Sent: 09 December 2025 14:23
To: Kerri Simpson; DC Admin
Subject: DOCO comments for application 2025/92836 at The Priory, Whitechapel Road, Cleckheaton, BD19 6HR

Condition 14- security measures:

Condition 16- lighting:

Street Lighting

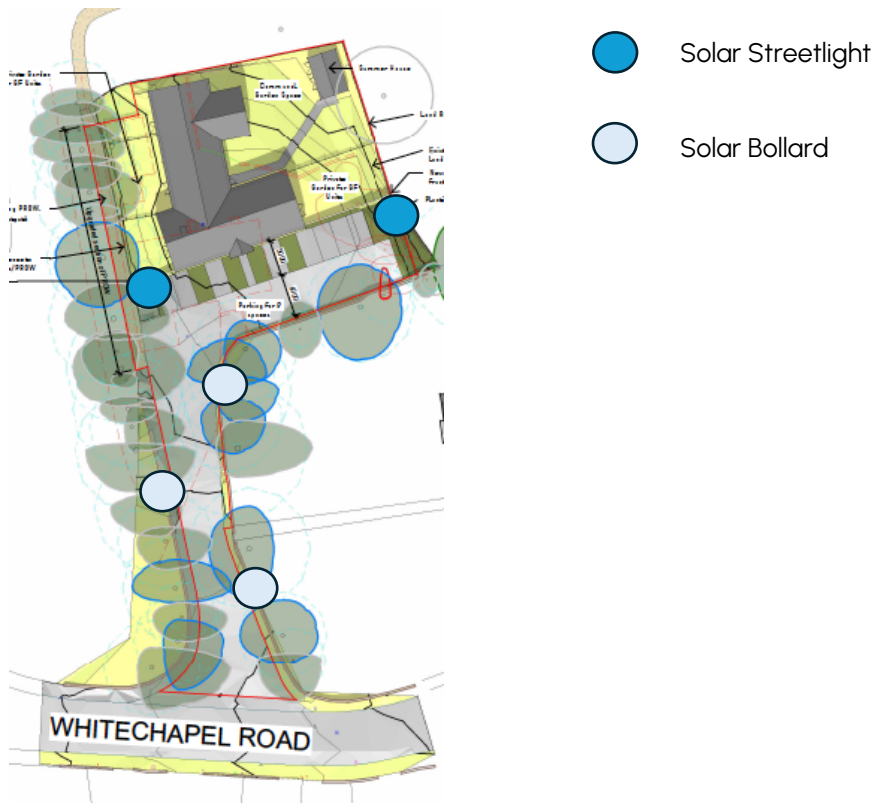
I note that bollard lighting has been removed from the 'Street Lighting' section of the Lighting Strategy document. The road and site access will be facilitated by Solar streetlights which will provide constant ambient lighting and become brighter when motion is detected.

Condition is discharged.
